Engineers comments regarding P/84/12/

APPLICATION P/84/12/

Site Address: Car Park Land off Sandy Road Pagham PO21 4SP

Description of Works: New access road & amendment to curtilage of Plot 1 - amendment to approval P/44/09/ (re-submission following refusal P/30/12/)

site layout

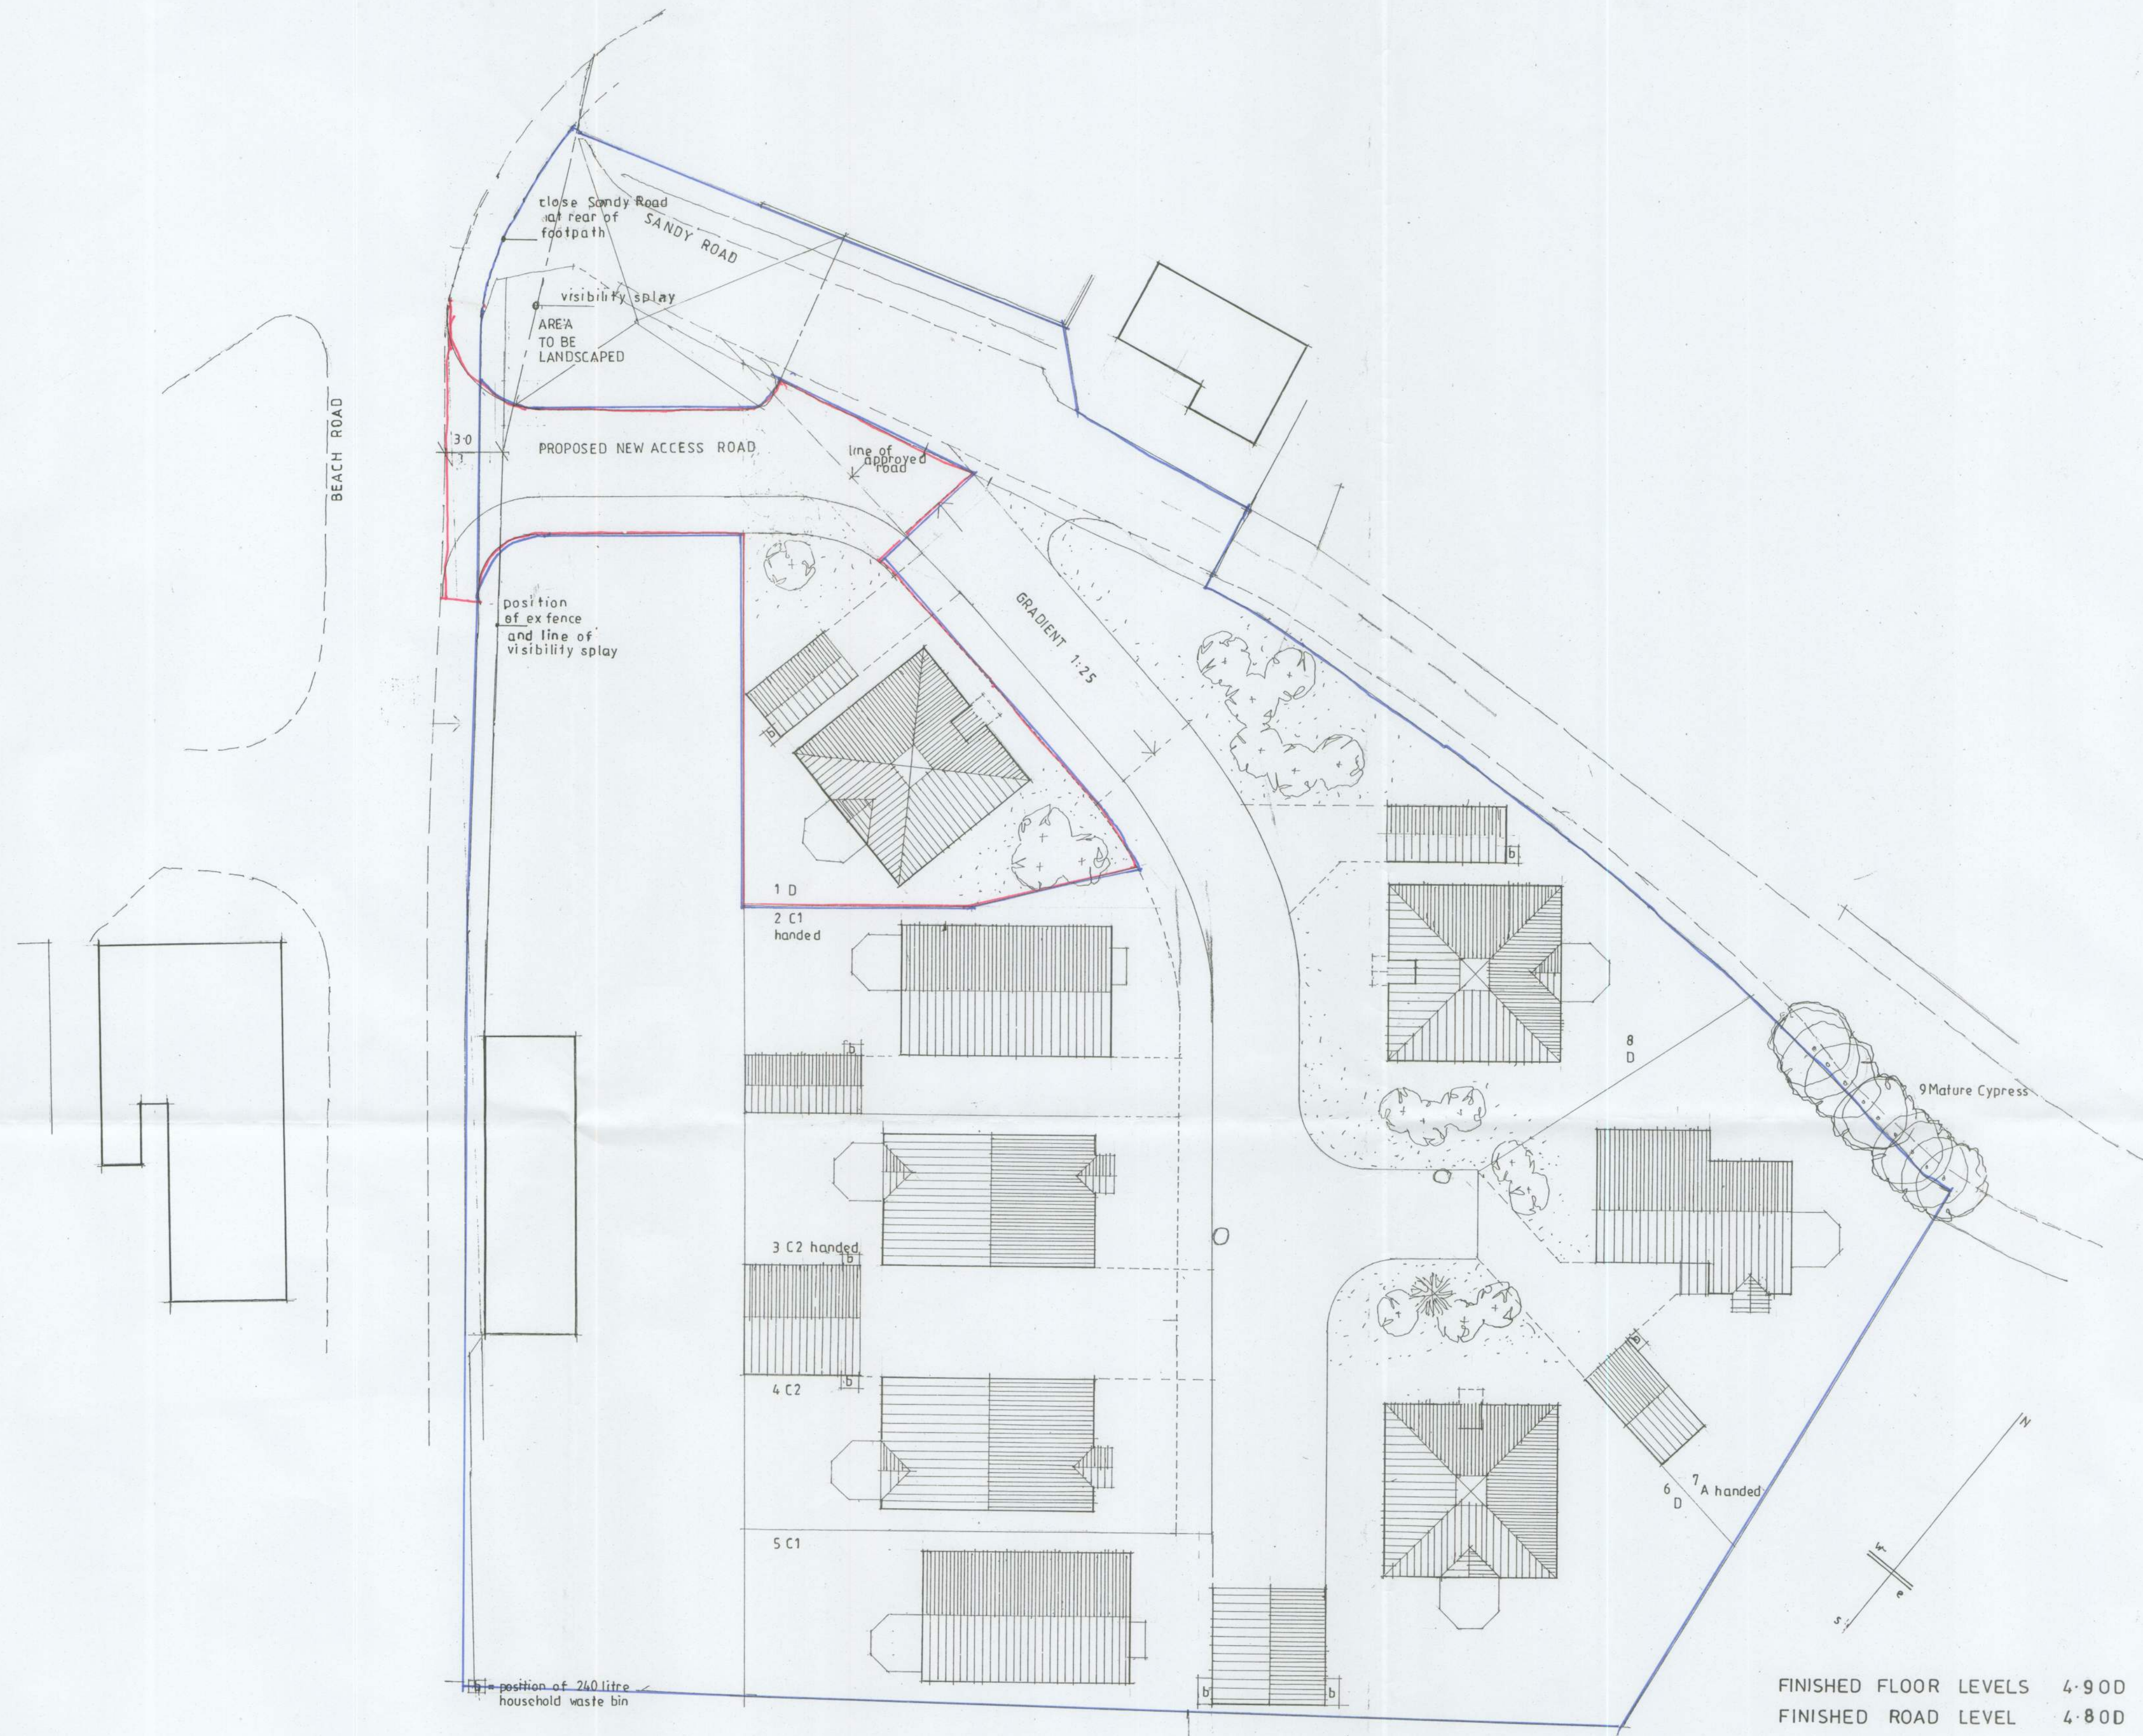
Surface water disposal designs will be required to show that the new road can be drained adequately so run-off does not flow onto the public highway or the housing.

Some ground water monitoring and percolation testing will be required to support soakaway design.

Development shall not commence until full details of the proposed surface water drainage scheme have been submitted to and approved in writing by the Local Planning Authority. Groundwater monitoring to establish highest annual ground water levels and Percolation testing to BRE 365, or similar approved, will be required to support the design of any Infiltration drainage.
